Ár dTag | Our Ref.
TII20-109962

Re. LA Road Development: Proposed Local Distributor Road 4 - Abbeyland Navan, Co. Meath
An Bord Pleanála case ref. PI 17 .307434

**Figure NTS 2 Opening Year (2022) AADT Differences between 'Do-Minimum' and 'Do-Something'**

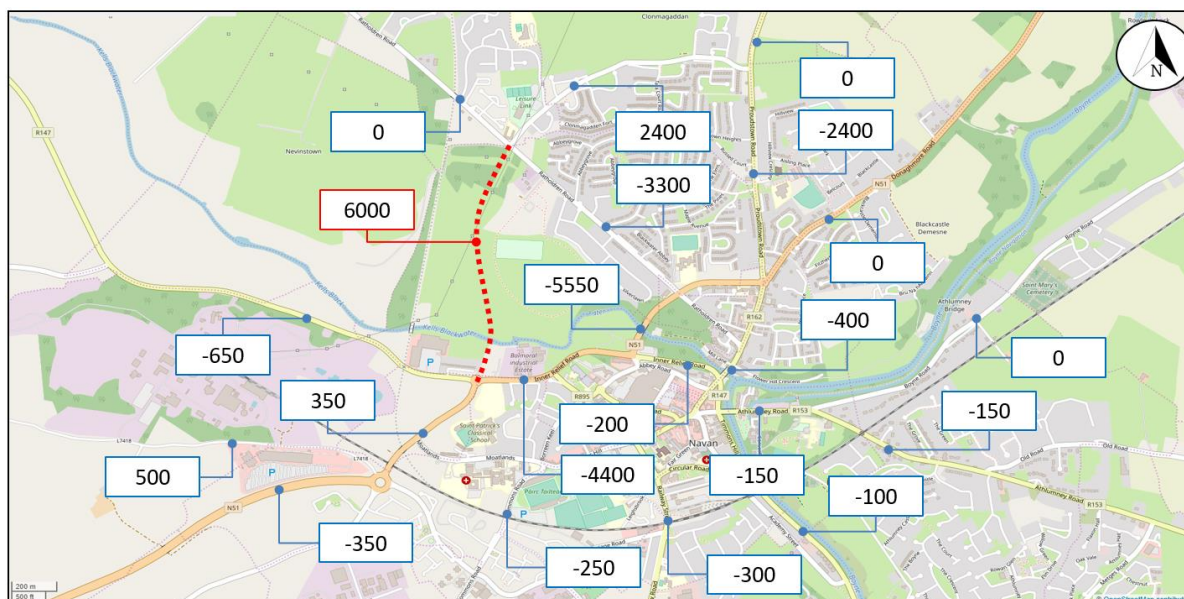
- b) Traffic analysis should also take account of potential redistribution of traffic generally, for example, AADT along the Clonmagadden Road increases from 3300 to 5700 (Year 2022) to 7450 (2037), a 140% increase. Redistribution of traffic may impact on the N51, national road, including the Round O junction. TII recommends that commentary and analysis, where necessary, of potential impacts to the national road and Round O junction should accompany any update to the Traffic Analysis undertaken.
